Our ref: NO/2022/114950/04-L01
Your ref: 3/2022/1003
Date: 06 April 2023

**DISCHARGE OF CONDITION 21 (COMPENSATORY STORAGE) FROM PLANNING PERMISSION 3/2021/0205.
LAND AT NEDDY LANE, BILLINGTON, BB7 9LL**

Environment Agency position

Title
Pre & Post Development Floodplain
Sheet 5 of 8

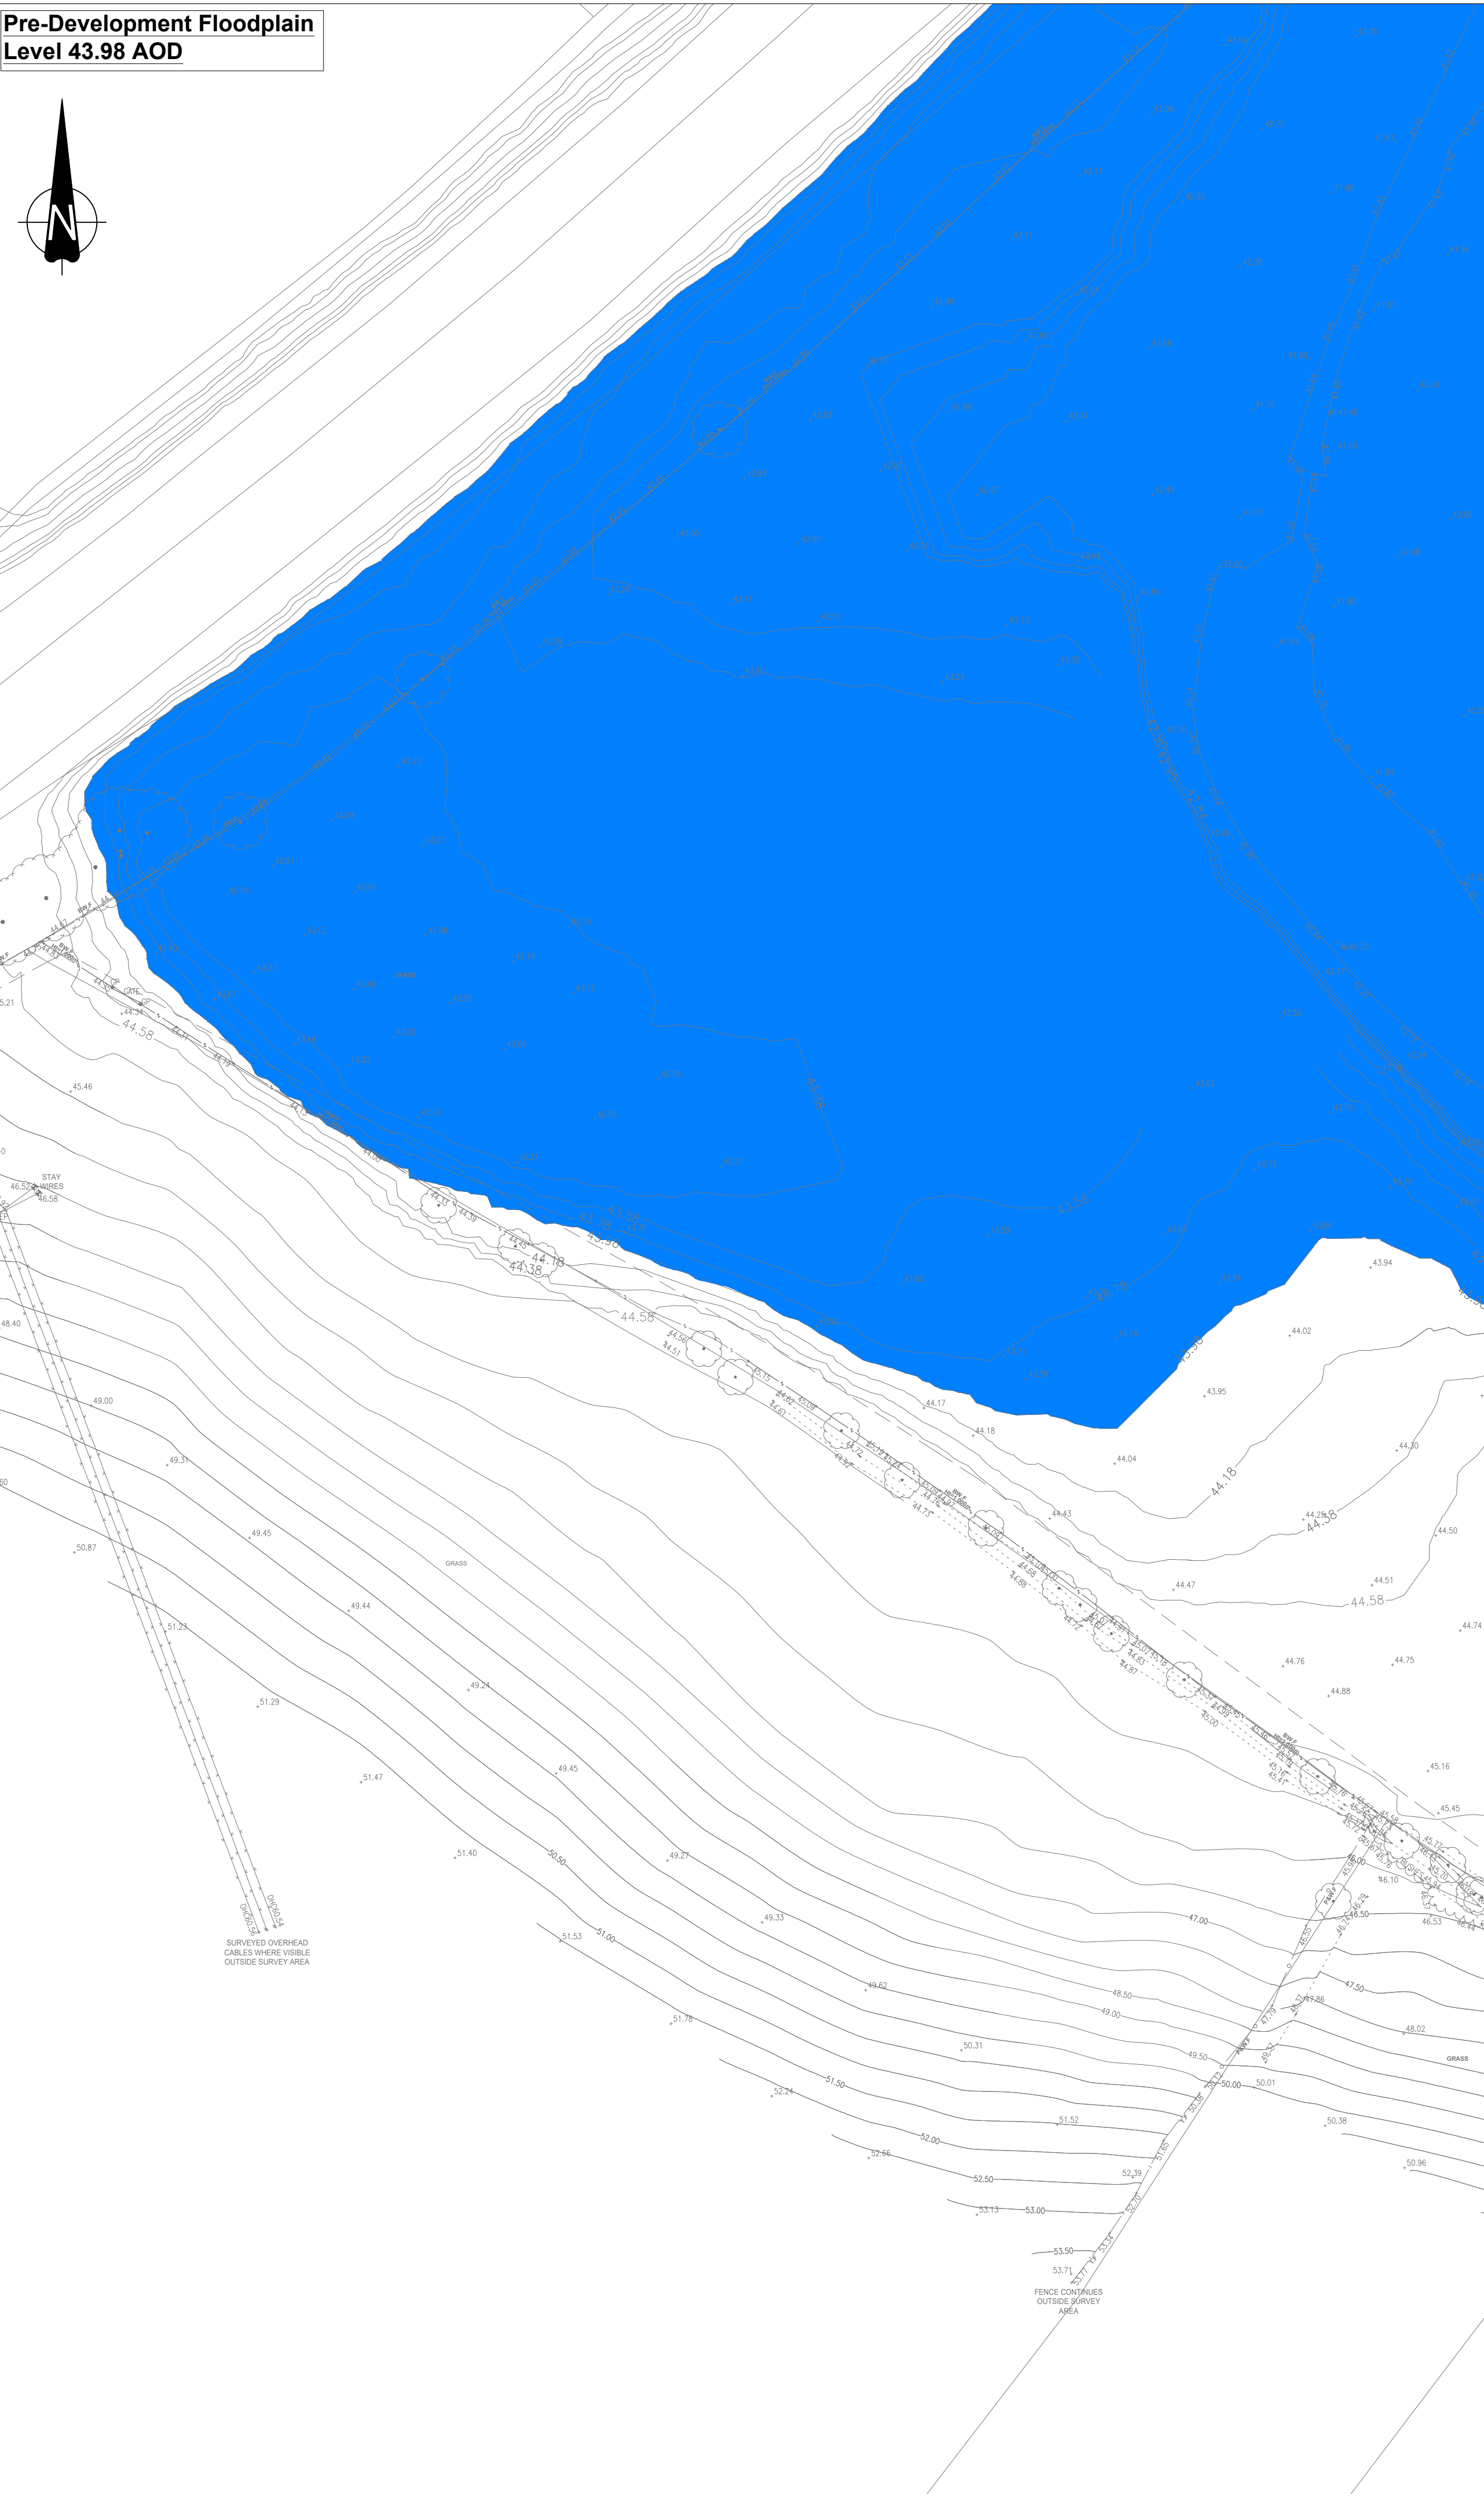
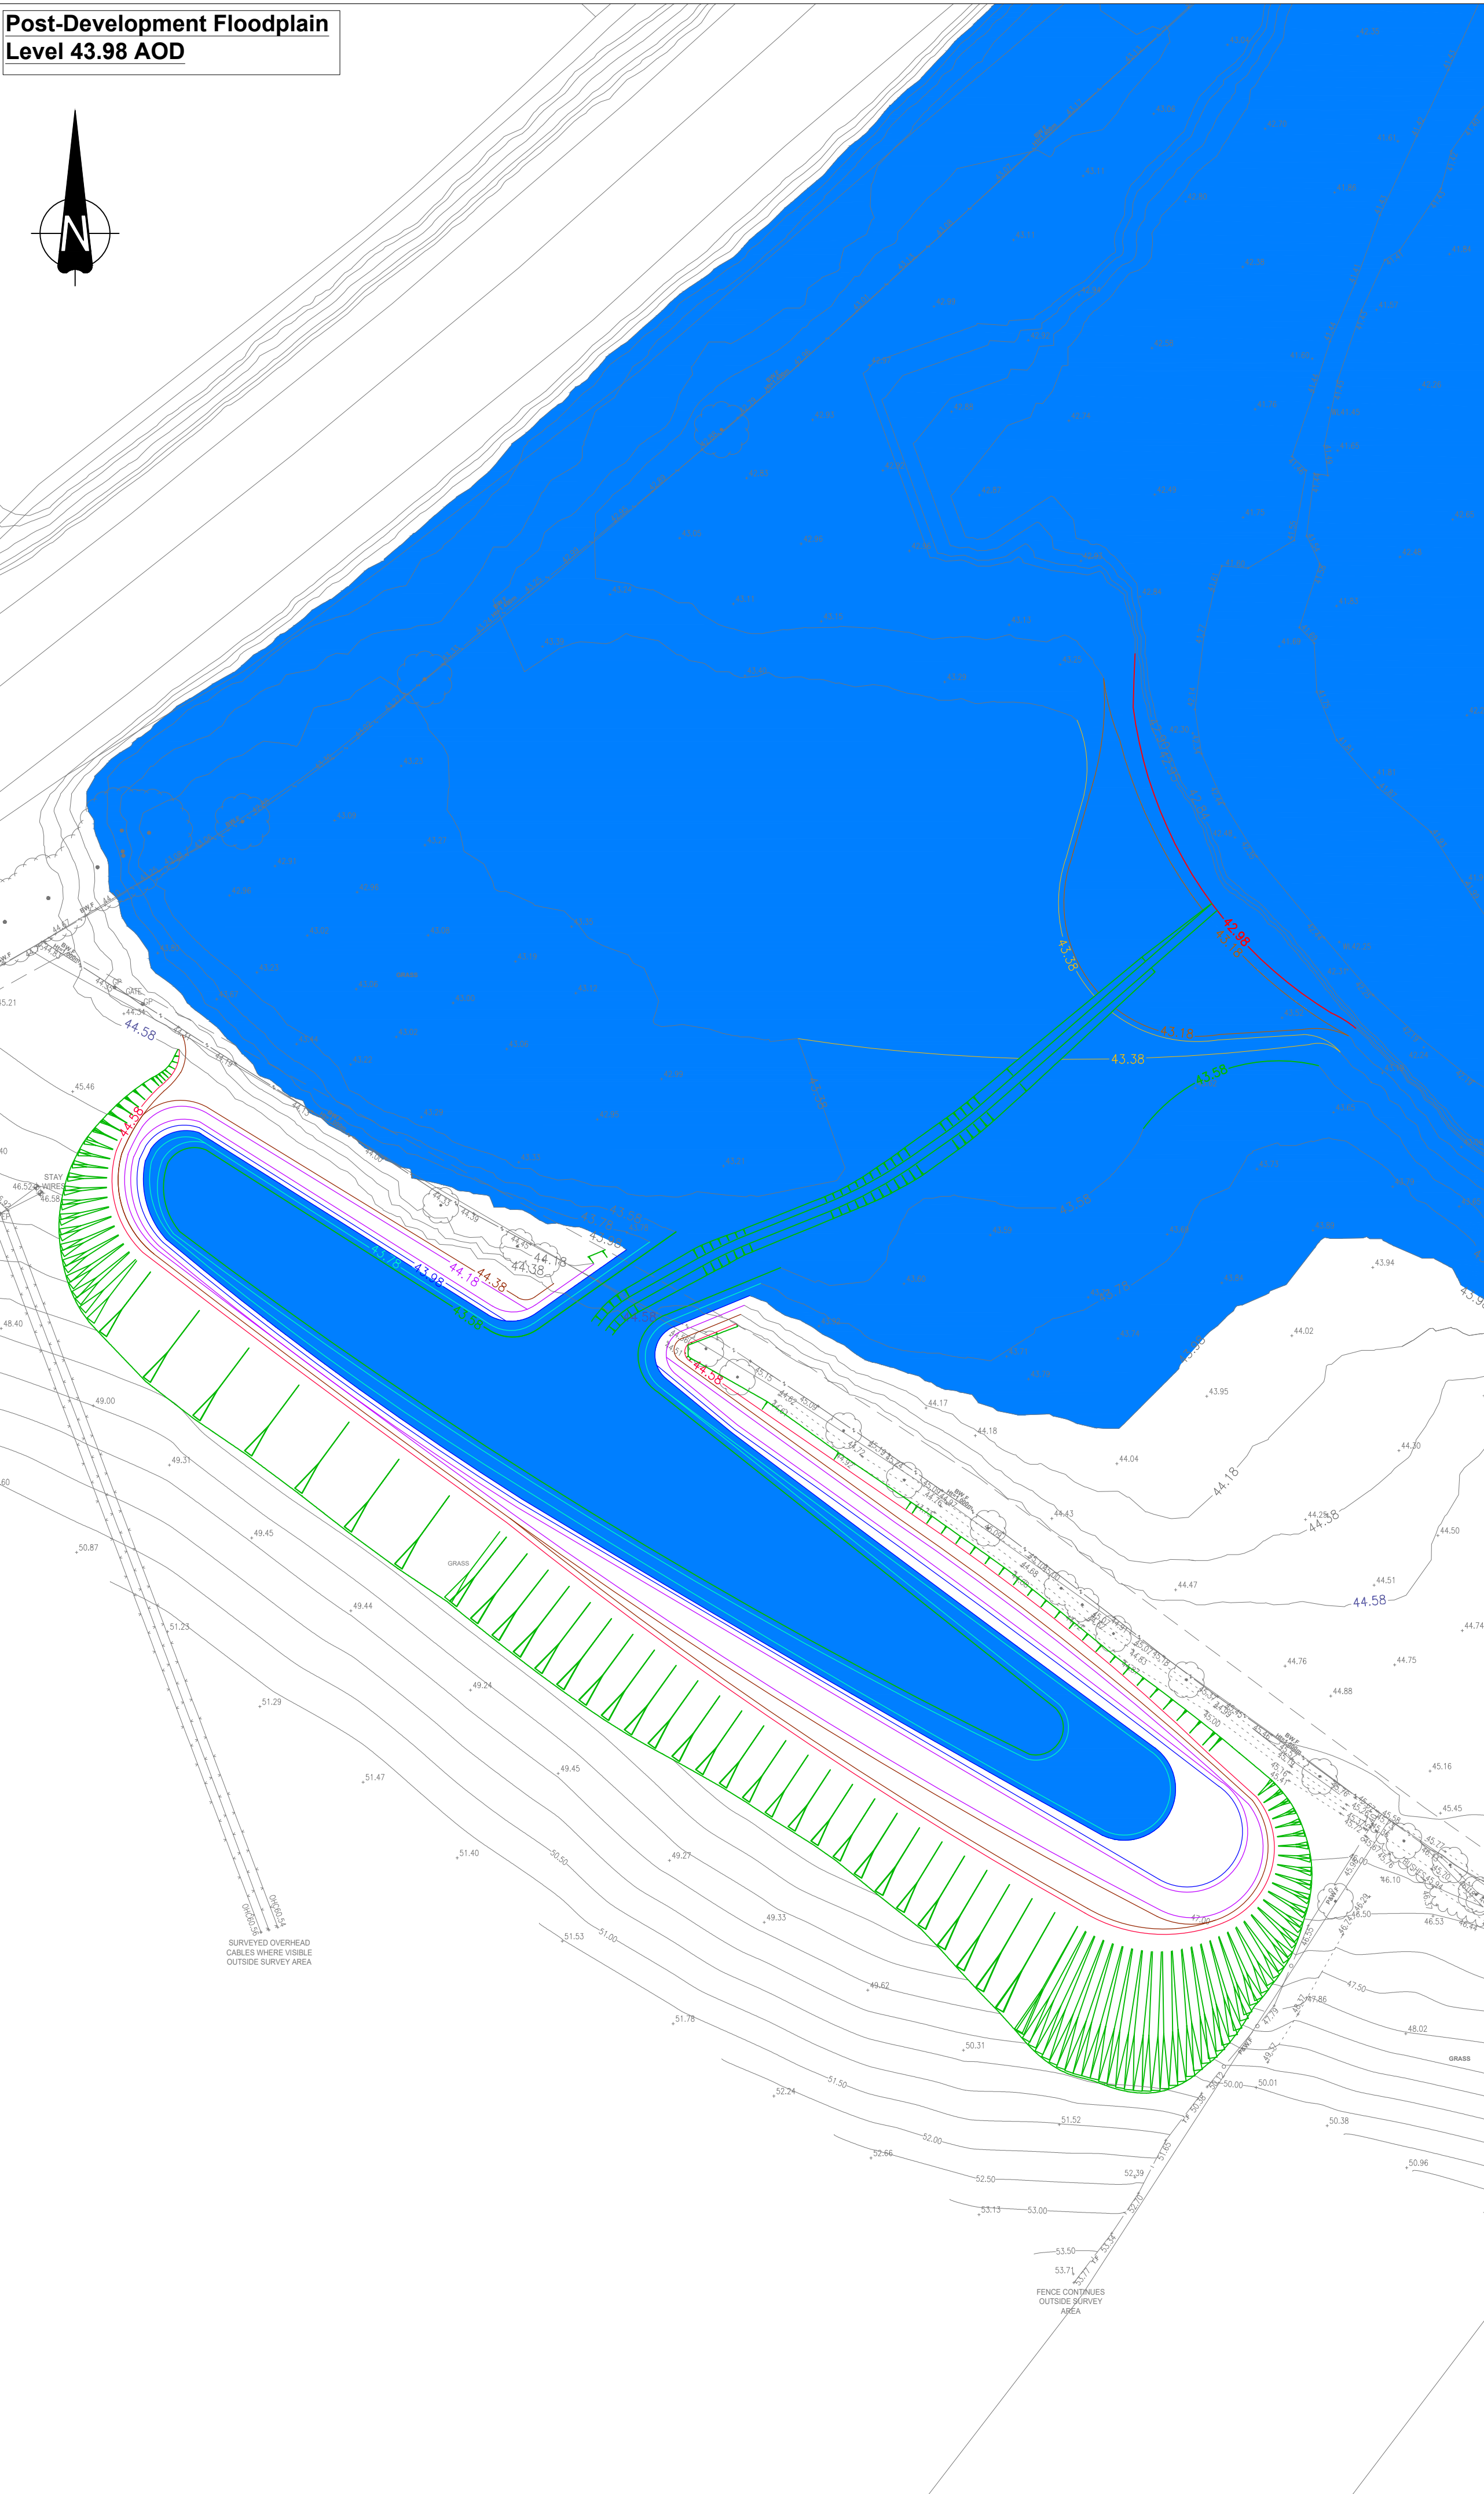
We have reviewed the details submitted to the LPA on the 21st March 23. We assume that the drawings are intended to show how flood water will propagate into the proposed flood storage area at 200mm increments to provide the required 'level for level' compensatory storage required for the proposed development platform.

The drawings do not appear to be derived from 2d hydraulic modelling, but rather an exercise in colour filling the relevant contour polylines. Therefore, we remain very concerned that the proposals are being progressed along an engineering cut and fill basis. Unfortunately, this means that there is still insufficient information regarding how the compensatory storage area will fill and drain during and after a flood event. As the submitted details do not satisfy the concerns outlined in our letter of 3 March 2023, we are currently unable to recommend the discharge of condition 21.
